DECISION DELEGATED TO HEAD OF PLANNING

Application No: H15-0213-26 **Applicant:** Mr P Macmanaman

Proposal: Proposed two storey extension to house and proposed rendering of the dwelling

Location: 90 Main Road Quadring Spalding

FRONT ELEVATION (PROPOSED)

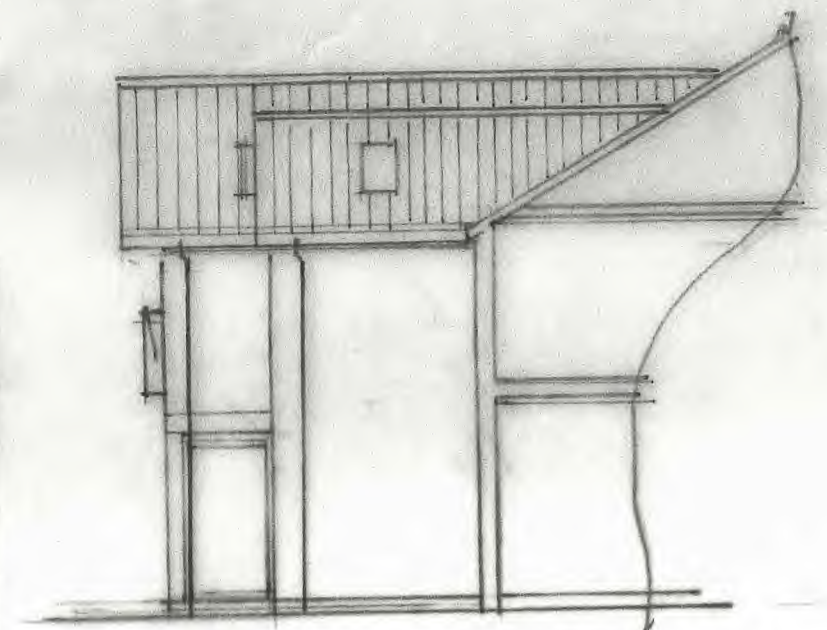
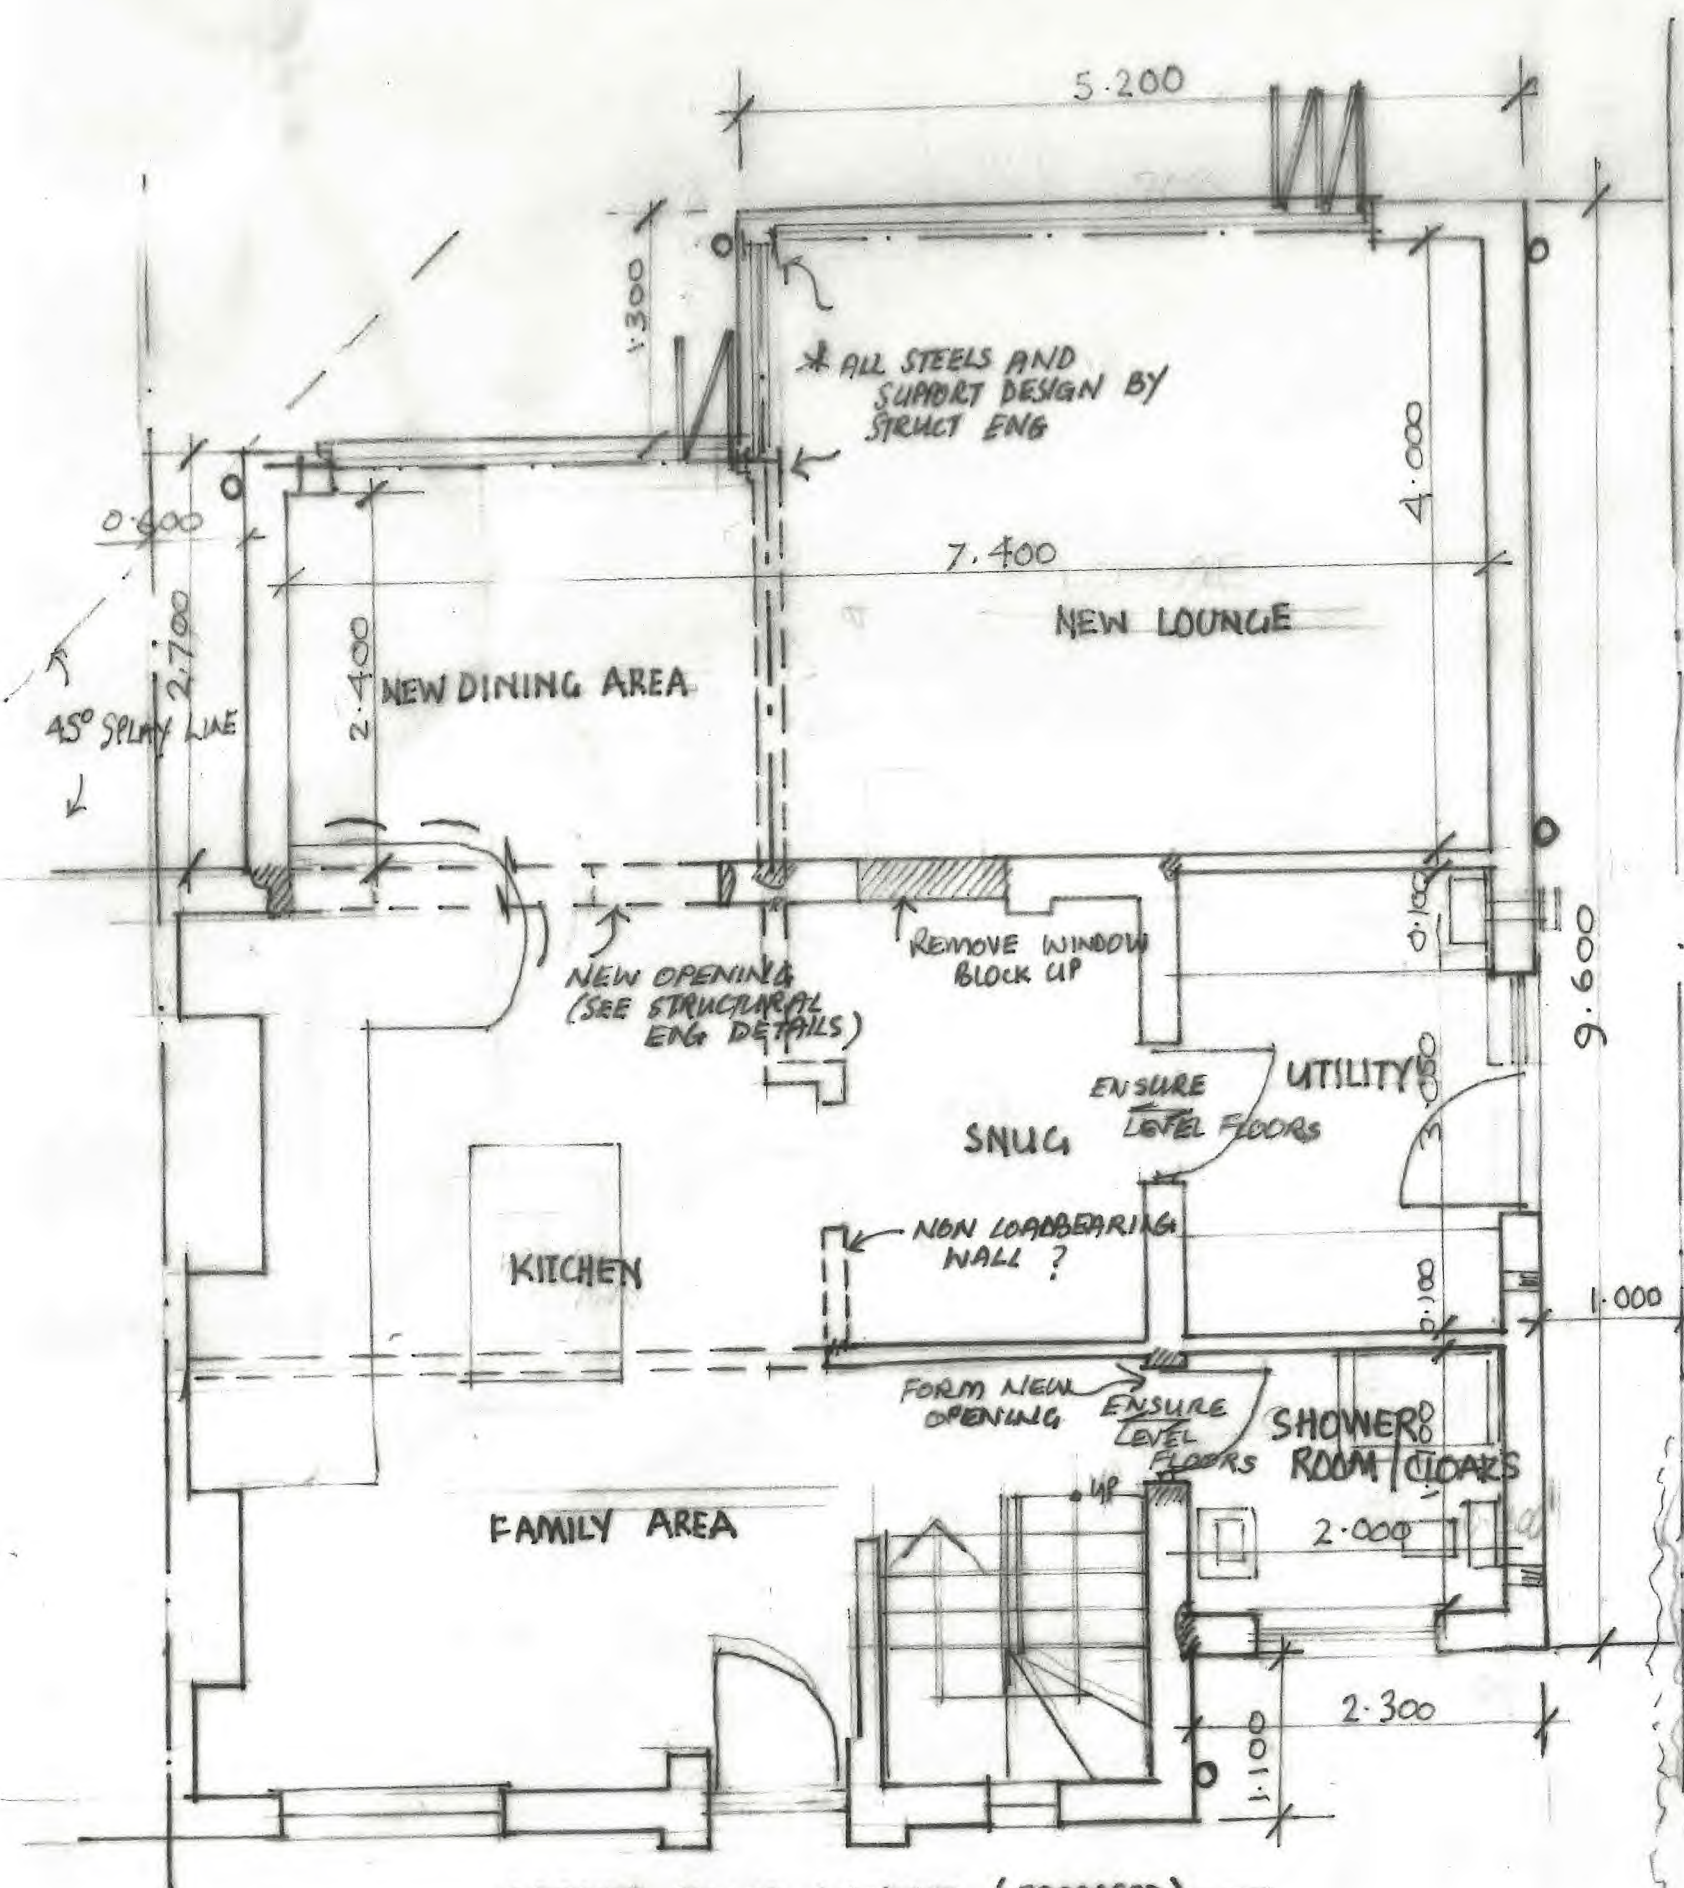
The extension is proposed on the north-western side of the dwelling. A hipped roof form is proposed, for which the ridgeline would be lower than the main part of the dwelling. For example, the ridgeline of the existing dwelling measures 7.4m in height whereas the extension would measure 7.1m in height. The eaves would be set at the same level as the eaves on the main dwelling.

The side extension would measure 2.3m in width towards the front of the site whereas the current extension measures approximately 3.3m in width. Therefore, the extension would not be as wide; however, the extension would be much taller. The front part of the extension would also be closer to the front elevation of the dwelling than the existing side extension. The extension would still be set back further to the rear than the principal elevation of the dwelling, as is the case for the current side extension.

A window is proposed at the first-floor level on the north-western side elevation which connects to a bathroom. Although this window would not face directly towards any neighbouring habitable windows, the window would face towards 92 Main Road. Therefore, it would be considered appropriate to require obscure glazing for this window in the interests of maintaining privacy. A ground floor window is also proposed on the side elevation; however, this would connect to a utility room and as this would not be considered as a habitable room, obscure glazing for this window would not be considered as necessary.

FRONT ELEVATION (PROPOSED)

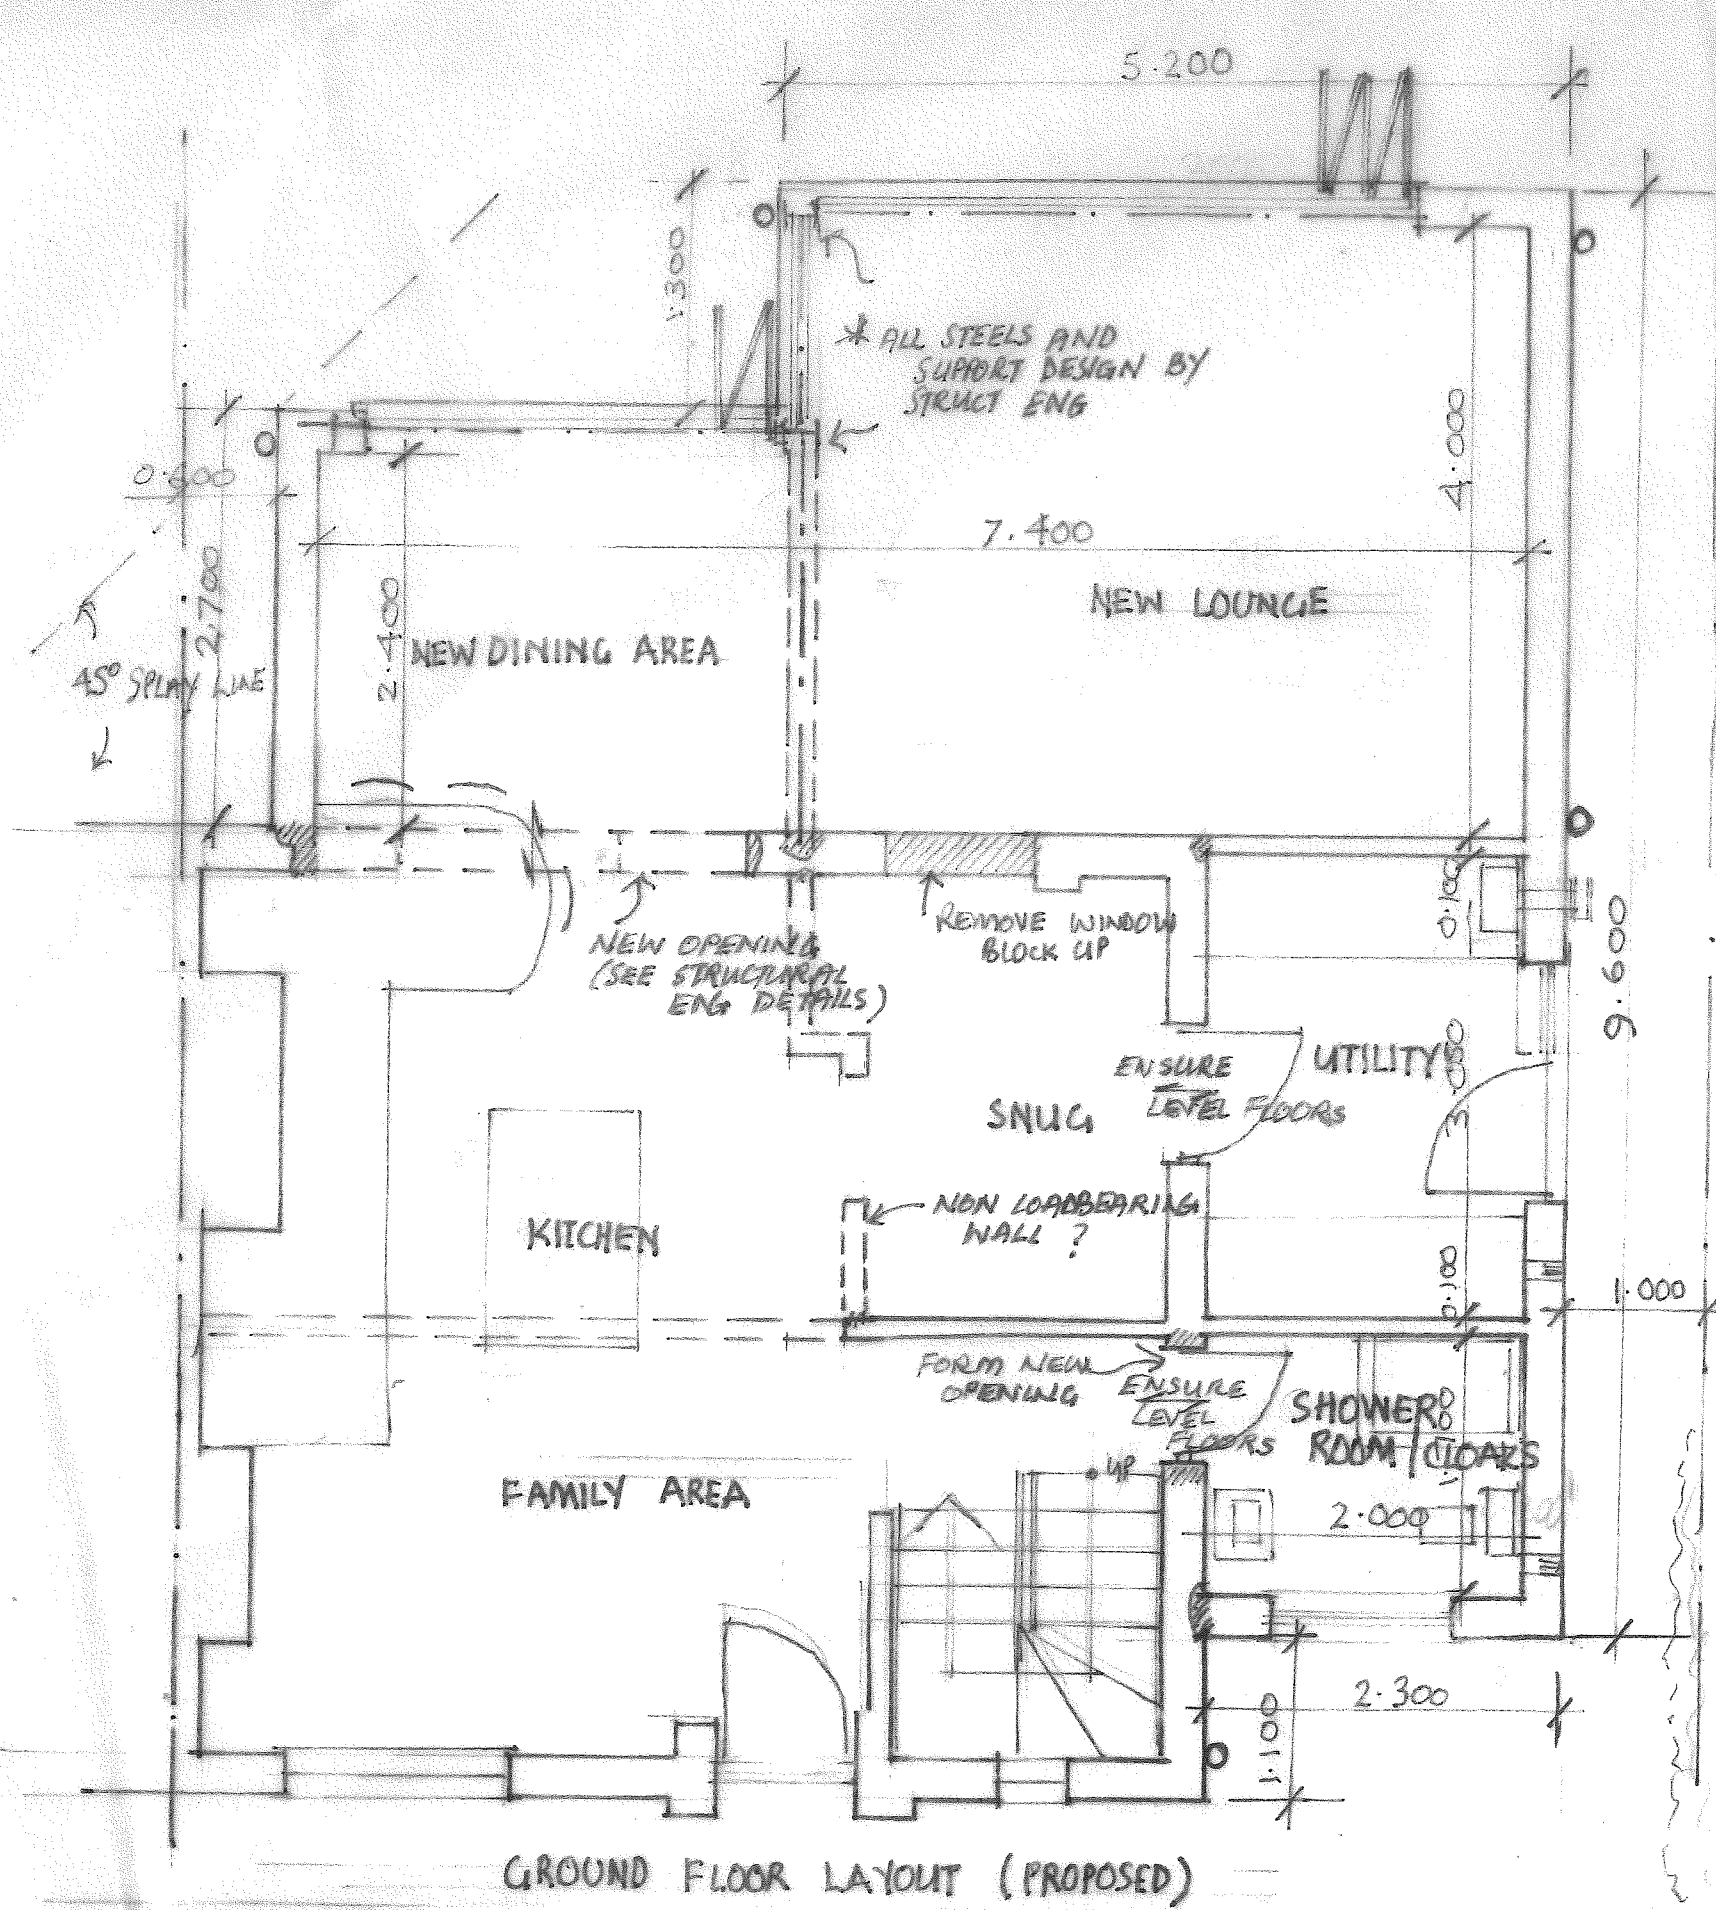
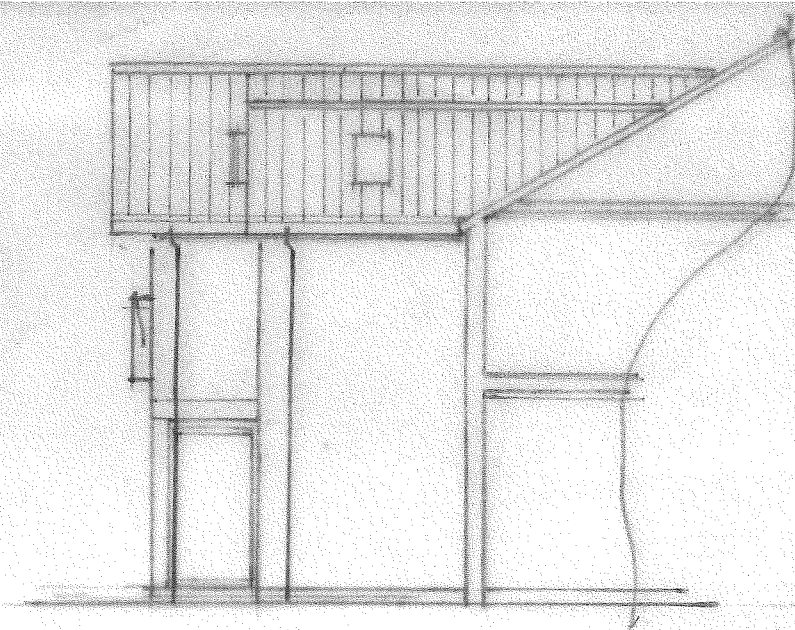
Initially, the submitted plans indicated that the proposed extension would feature white render, and it appeared that the host dwelling would remain featuring red brickwork facades. It was considered that this would result in a disjointed appearance at the front of the site and alternative materials were requested. Furthermore, the application form referred to cream render and as such, the submitted details were inconsistent.

As set out previously, this was discussed with the applicant's agent, and it was clarified that the proposal sought to install render on both the proposed extension and the existing dwelling. As this was unclear based on the submitted information, it was agreed that the description of development should be updated to reflect this, and an amended elevation plan was provided to clarify that cream render is proposed on both the extension and the original dwelling.
